**To:** Jack Cloud, Chair Development Review Board

**From:** Vicente M. Quevedo, Planner

**RE:** Project 1000501, 14EPC-40062 Site Development Plan for Building Permit

SHEET 1
12-9-14
DATE
PROJECT NO.

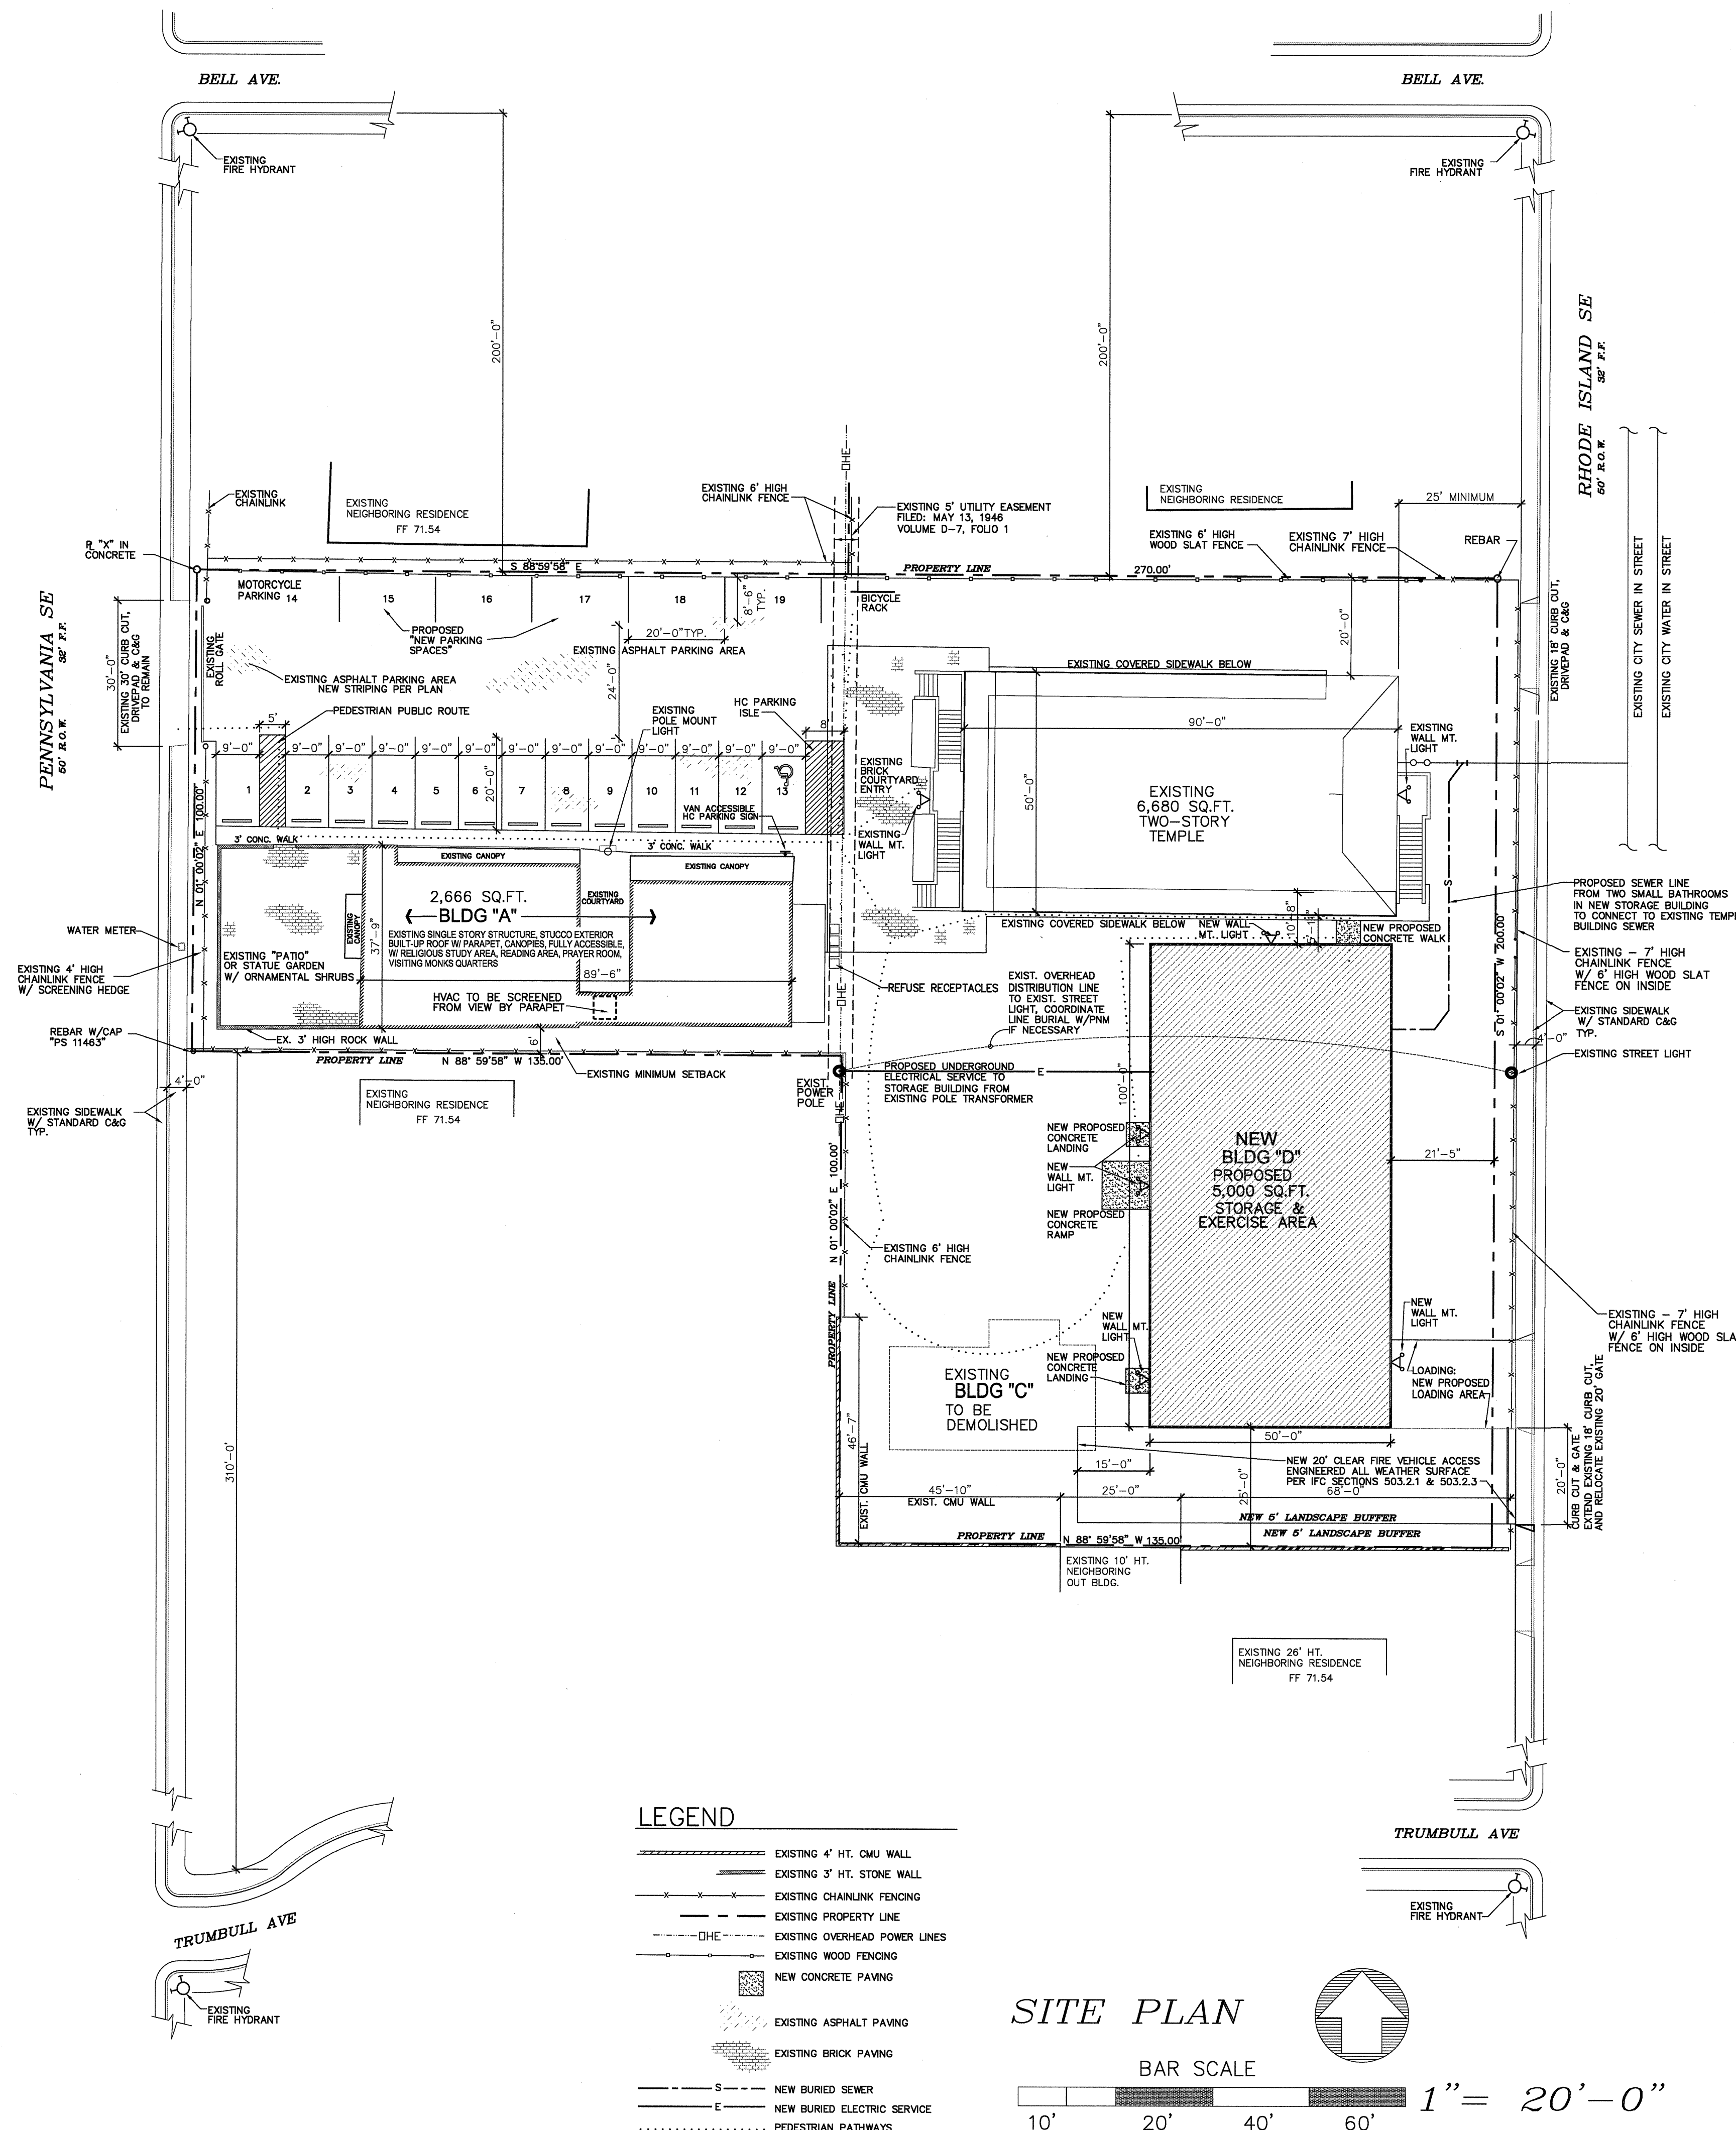
- The applicant informed staff that following a meeting with the Fire Marshal's Office that the proposed 5,000 square foot warehouse building would need to be moved 5 feet to the north in order to provide fire truck access. This has been reflected on the site development plan for building permit. The applicant refers to this as Condition 8 in the DRB narrative however this condition was not included as part of the EPC Official Notice of Decision.
